Application for a non-material amendment following a grant of planning permission.

Erection of 2 x 3 bed detached chalet bungalows with associated parking and amenity space including the demolition of the existing house and garage.

Reference number: FG/152/19/PL

drawing number
RS18.54.PL04N

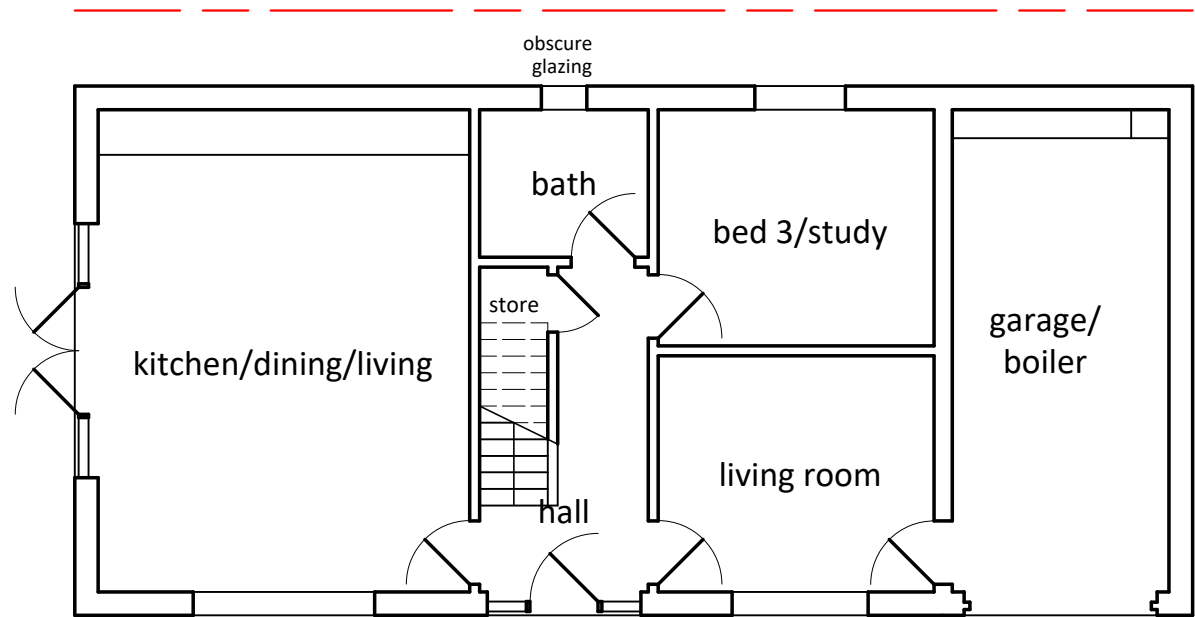
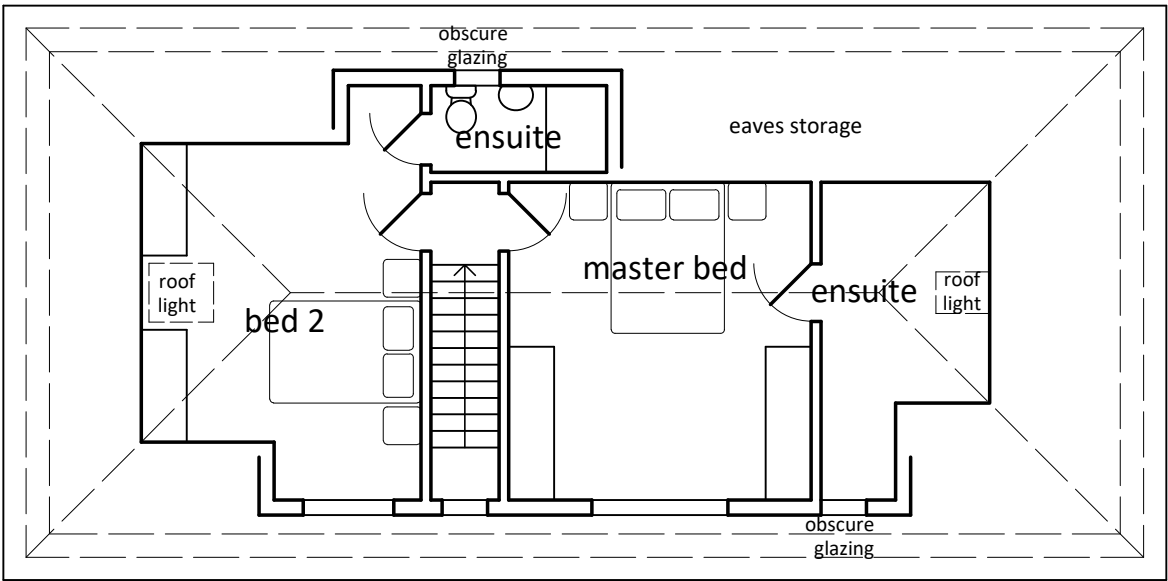
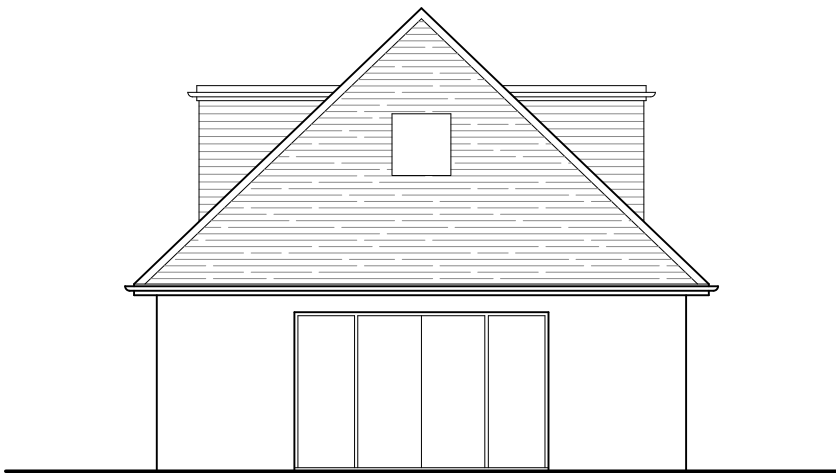
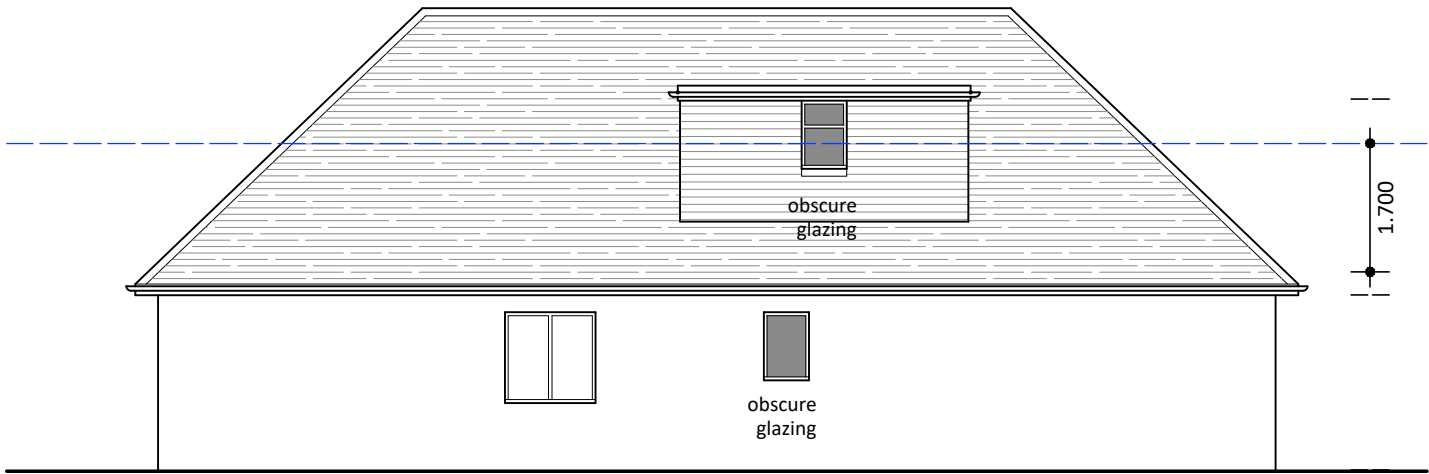
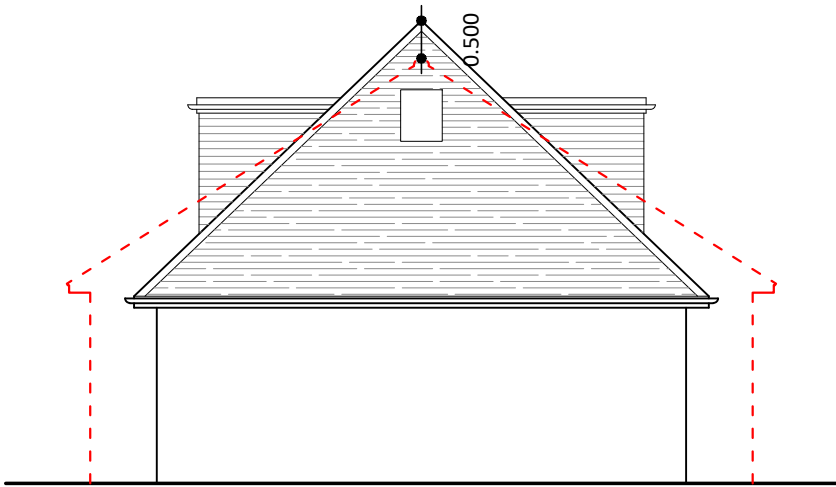
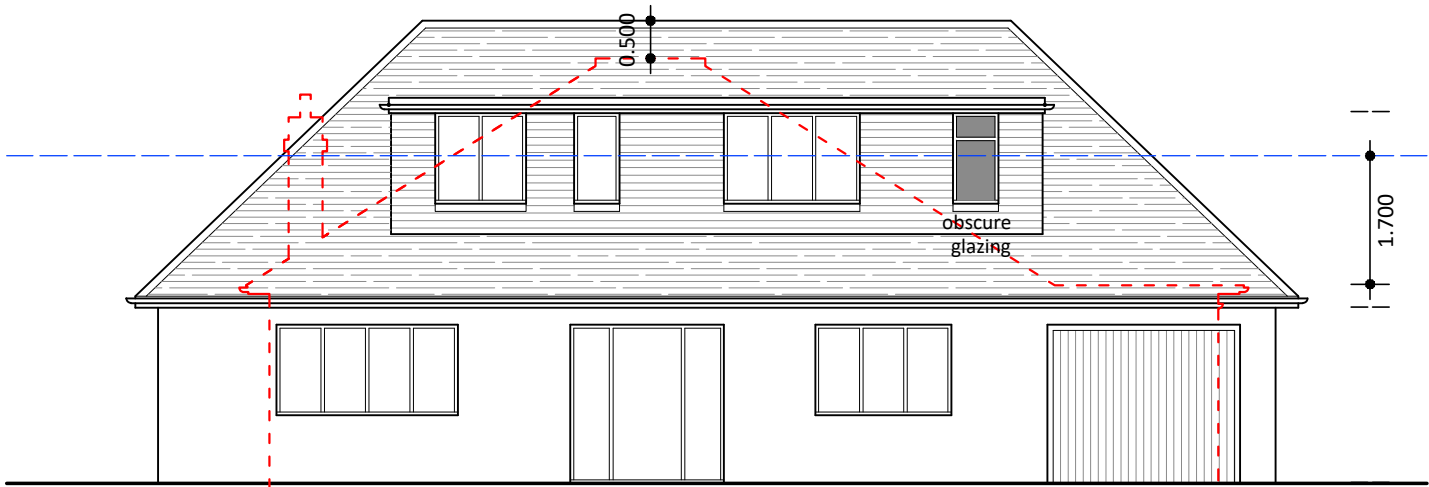
- removal of garage window to no. 40
- removal of east facing rooflight to master bedroom ensuite of no. 40
- finalise the window designs to include the requirements of planning condition 6 (obscured glass & fixed glazing to 1700mm height on specified elevations)

- removal of garage window to no. 40 as not required.
- removal of east facing rooflight to master bedroom ensuite of no. 40 as not required.
- finalise the window designs to include the requirements of planning condition 6 (obscured glass & fixed glazing to 1700mm height on specified elevations).
